Add a block with the following:
PCD No. COM2413

FINAL LANDSCAPE PLAN

BEAR CLAW
7301 COLE VIEW
CLAREMONT BUSINESS PARK LOT 32-2
EL PASO COUNTY, COLORADO SPRINGS, CO 80915

COUNTY FILE NO. PPR-07-007
PCD File COM2413
AAL-1141-07

FINAL LANDSCAPE PLAN

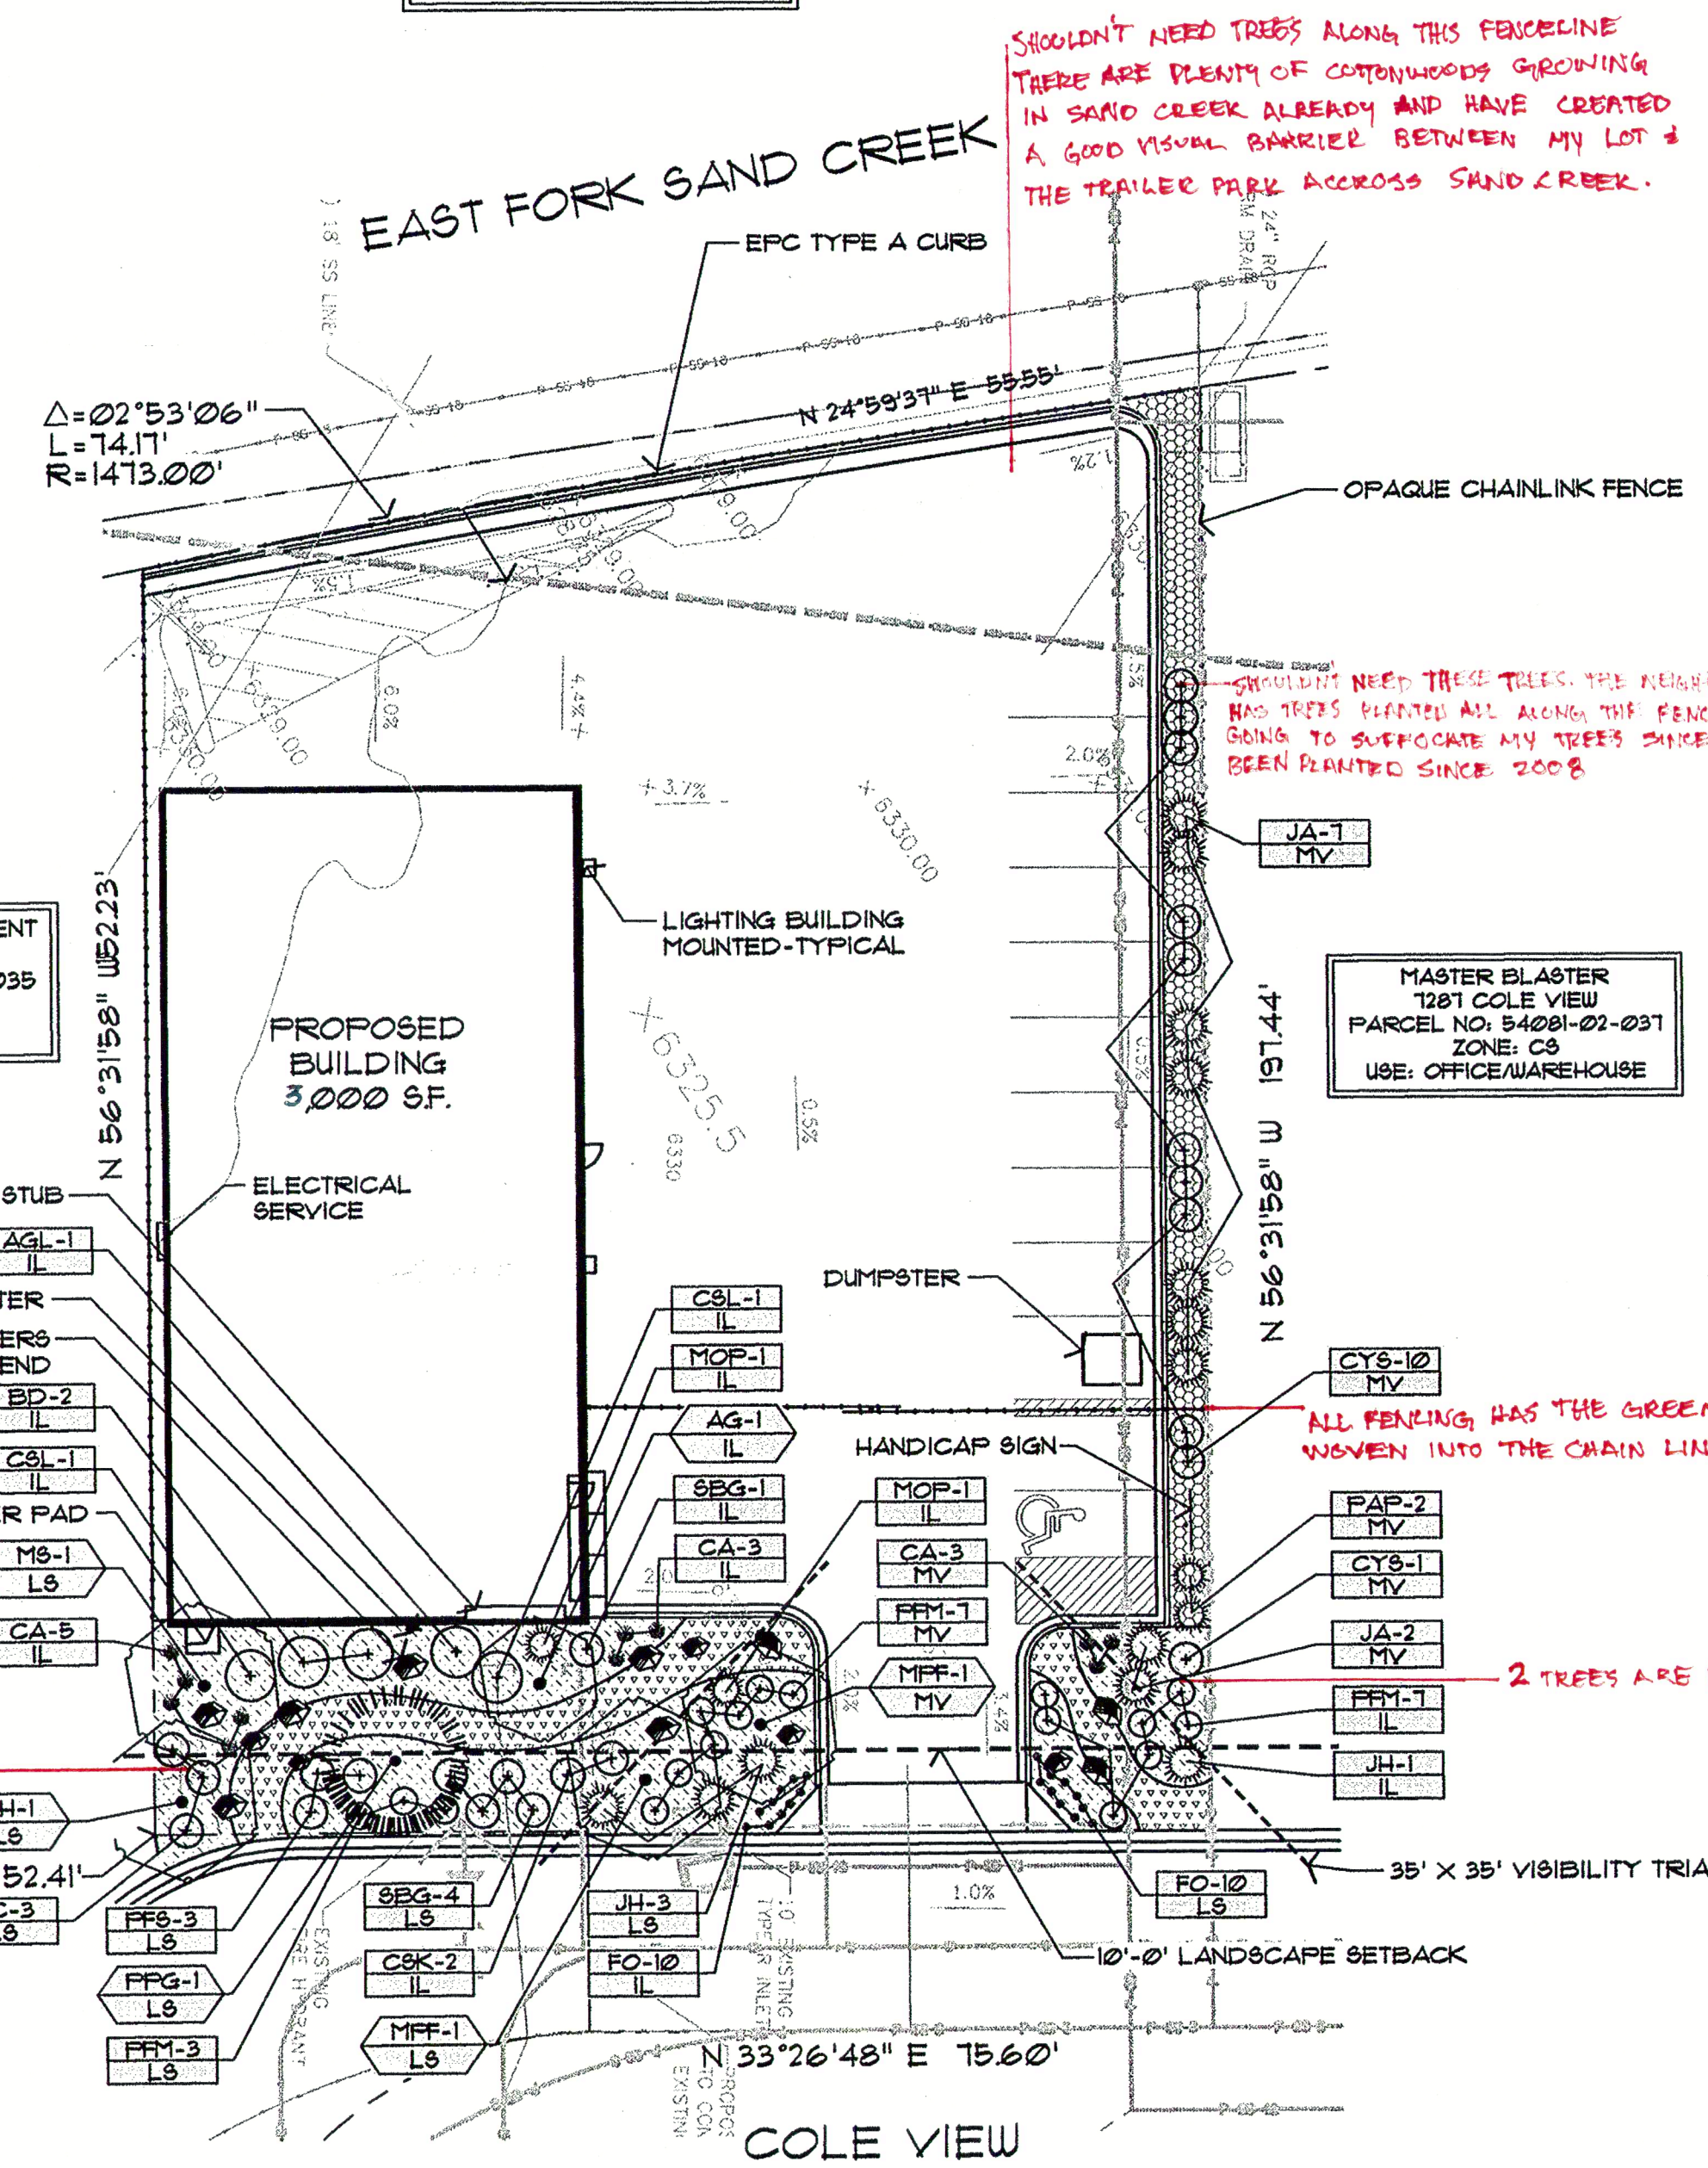
\$6.2.2.F.2 - Required Ground Cover. Unless utilizing the principles of xeriscaping, required landscape areas shall include a minimum of 30% ground cover by living or synthetic grass or other living plant materials at maturity. The remaining 70% of the required landscape area may be covered with bark, wood chips, rock, stone, or other landscape materials. No other areas within required landscape areas shall remain bare. The foliage crown of trees shall not be counted in meeting the ground cover requirement.

3,300 x .3 = 990 sq ft of plant cover required
552.17 sq ft of plant cover proposed

Add an additional 437.83 sq ft of plant material

- Roadway trees 128/30=4.3
Required roadway trees 4
Proposed roadway trees 3
Provide one additional roadway tree
- Internal landscape trees 3,300/500=6.6
Required internal landscape trees 7
Proposed internal landscape trees 3
Provide four additional internal landscape trees

Roadway trees 128/30=4.3
Required roadway trees 4
Proposed roadway trees 3
Provide one additional roadway tree

Internal landscape trees 3,300/500=6.6
Required internal landscape trees 7
Proposed internal landscape trees 3
Provide four additional internal landscape trees

§6.2.2.D.2 - Buffer Between Non-Residential, Multifamily Residential and Single-Family/Duplex Uses.

(a)Where Required. A buffer is required in the following situations:(i)Along the lot, parcel, or tract line on the non-residential use property between the non-residential use and a residential zoning district.(ii)Along the lot, parcel, or tract line on the multifamily use property between the multifamily use and a single-family or duplex zoning district.(iii)On the residential side of the project when use to use compatibility is a concern.

(b)Depth and Planting Standards. The required buffer shall be a minimum of 15 feet deep. The minimum number of trees in the buffer shall be 1 tree for every 25 feet of common lot, parcel, or tract line. A minimum of 1/3 of the trees shall be evergreen trees.

(c)Opaque Fencing or Wall Required. An opaque fence or wall with a minimum height of 6 feet is required along the lot, parcel, or tract line except where the adjacent single-family or duplex residential zoning district or use abuts a required roadway landscaping area.

(d)Minimum Ground Covering Required. Bark, wood chips, rock, stone, or other natural/synthetic landscape material shall be used as a non-living ground cover. Areas of a required buffer not covered in approved non-living ground cover material shall be covered in a living plant material.

Provide the required buffer.

§6.2.2.F.2 - Required Ground Cover. Unless utilizing the principles of xeriscaping, required landscape areas shall include a minimum of 30% ground cover by living or synthetic grass or other living plant materials at maturity. The remaining 70% of the required landscape area may be covered with bark, wood chips, rock, stone, or other landscape materials. No other areas within required landscape areas shall remain bare. The foliage crown of trees shall not be counted in meeting the ground cover requirement.
3,300 x .3 = 990 sq ft of plant cover required
552.17 sq ft of plant cover proposed
Add an additional 437.83 sq ft of plant material

§6.2.2.G(b) Refuse Areas Screened. Refuse collection areas, including trash bins, shall be screened from view from adjacent properties and roads by an opaque wall or fence, architectural elements, dense evergreen plantings with a minimum planting height of 6 feet, or berms with dense plantings creating an opaque appearance with a minimum height of 6 feet.

Provide details of your screening proposal.
